Permit Number: 090403

has permission to New 24' x 36' 2 bedroom Ranch style Single family home w/ 1 car garage

AT 29 DAKOTA ST CB# 407 H016001

RE: C. of O. for # 29 Dakota Street
(Id#2009-0042) (CBL 407 H 016001)

Drawing Name:
Site & Utility Plan

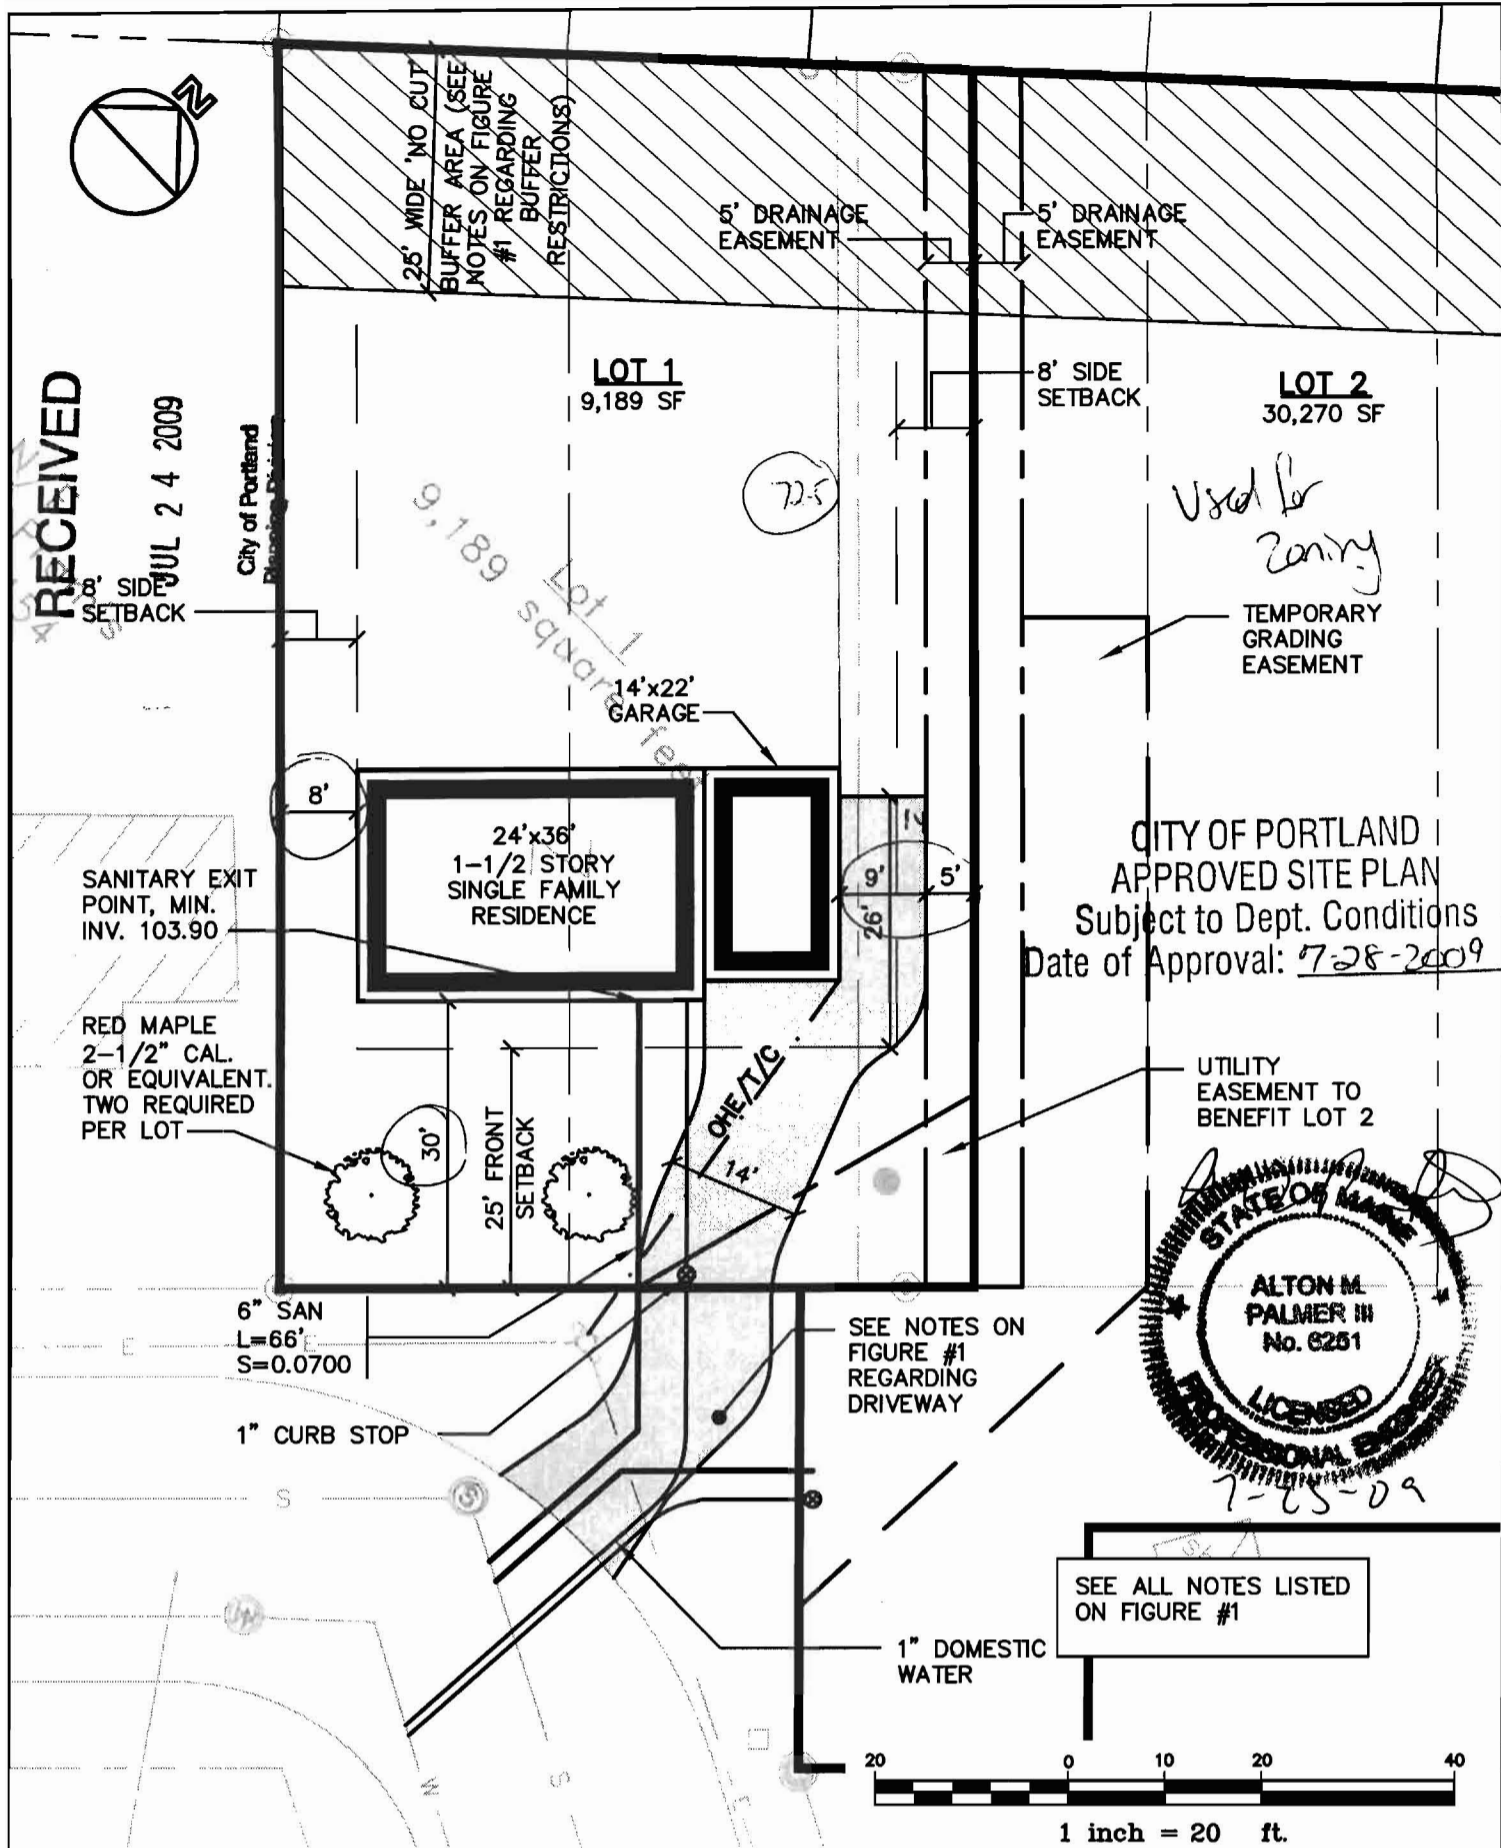
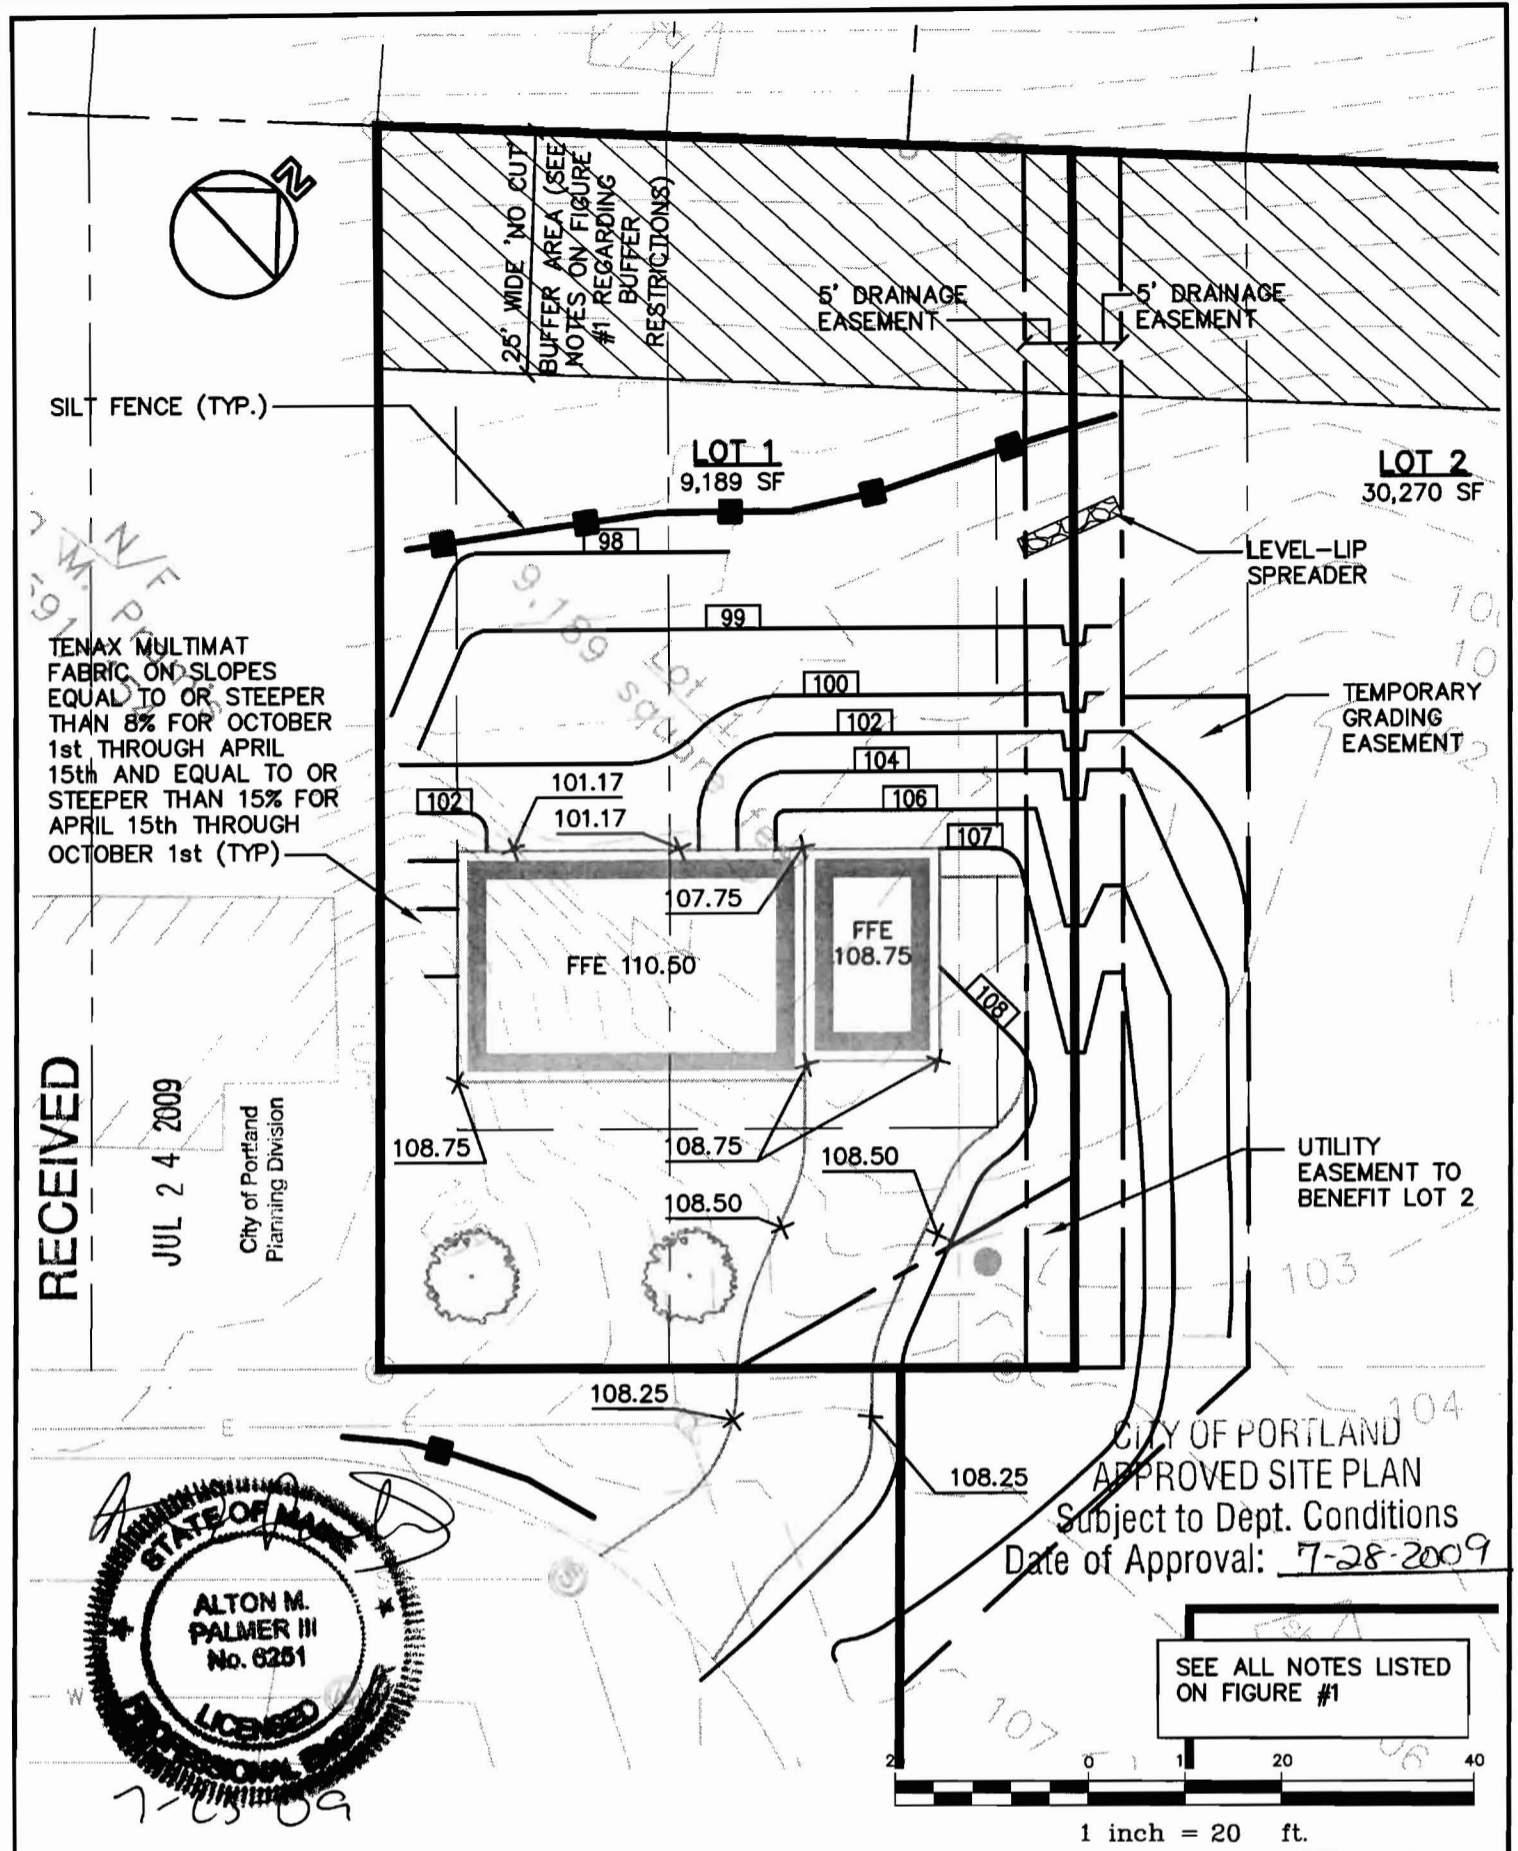
- 1) As discussed during the review process, the property must be clearly identified prior to pouring concrete and compliance with the required setbacks must be established. Due to the proximity of the setbacks of the proposed structure, it may be required to be located by a surveyor.
- 2) This property shall remain a single family dwelling. Any change of use shall require a separate permit application for review and approval.
- 3) This permit is being approved on the basis of plans submitted. Any deviations shall require a separate approval before starting that work.

SECTION THRU HOUSE

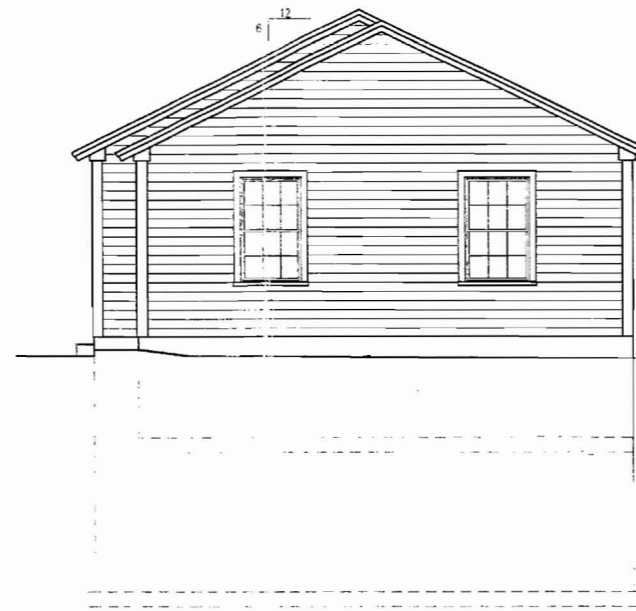
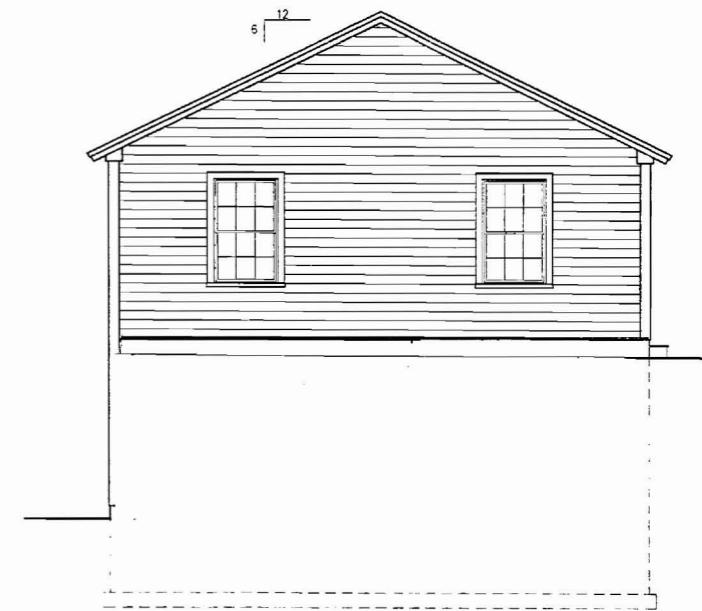
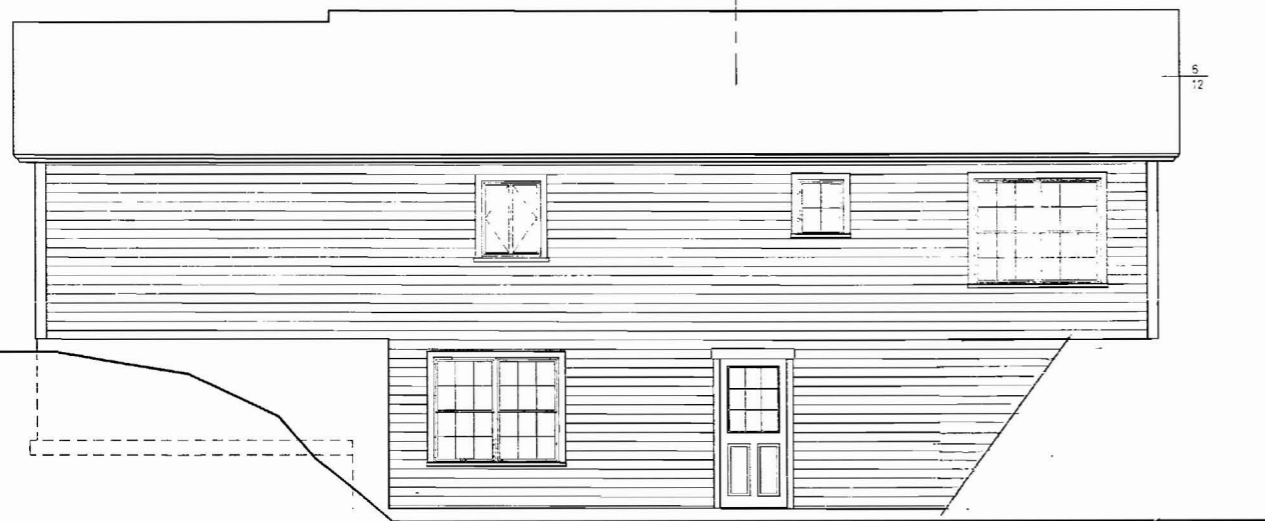
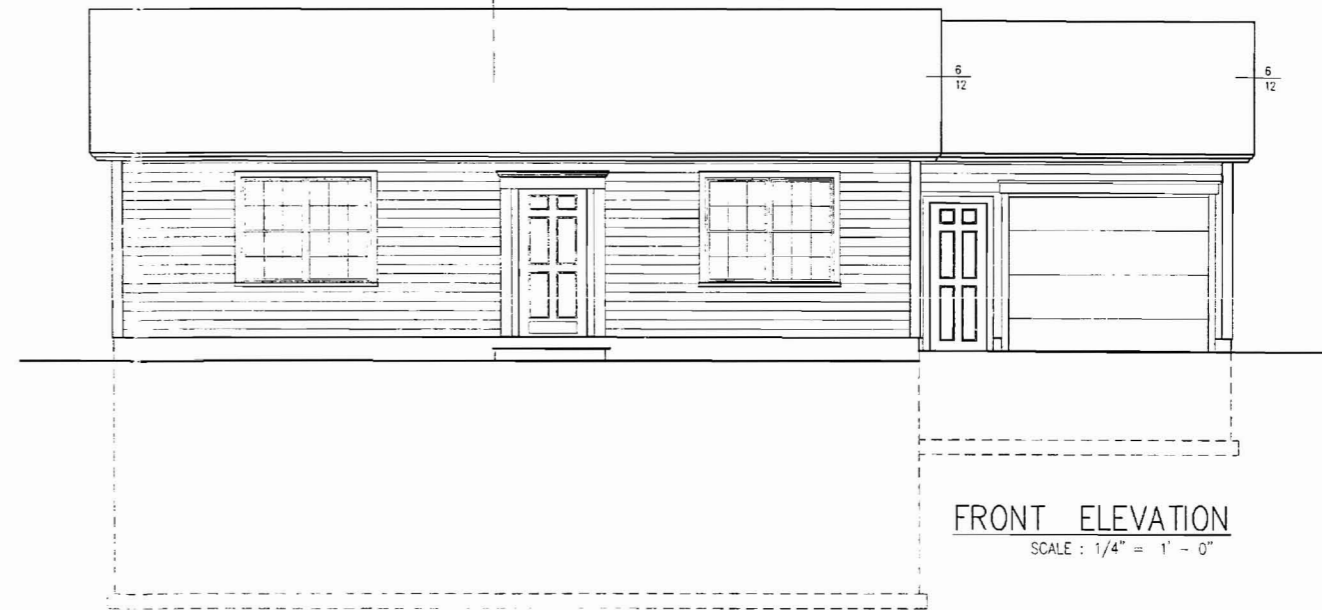
6/18/2009-amachado: Received email from Jean that the review could move forward once the revised siteplan & deed are received. I called Jim Wolf. The siteplan on the PDF does not scale. The required notes are not included and there is no deed. I need a full size plan of A2(elevations) and I need an elevation that shows the average grade in relation to the basement - Is more than half above grade?

6/19/2009-amachado: Dwight Brackett brought in a revised elevation plan both full size & 11" x 17" which shows only a partial daylight basement.
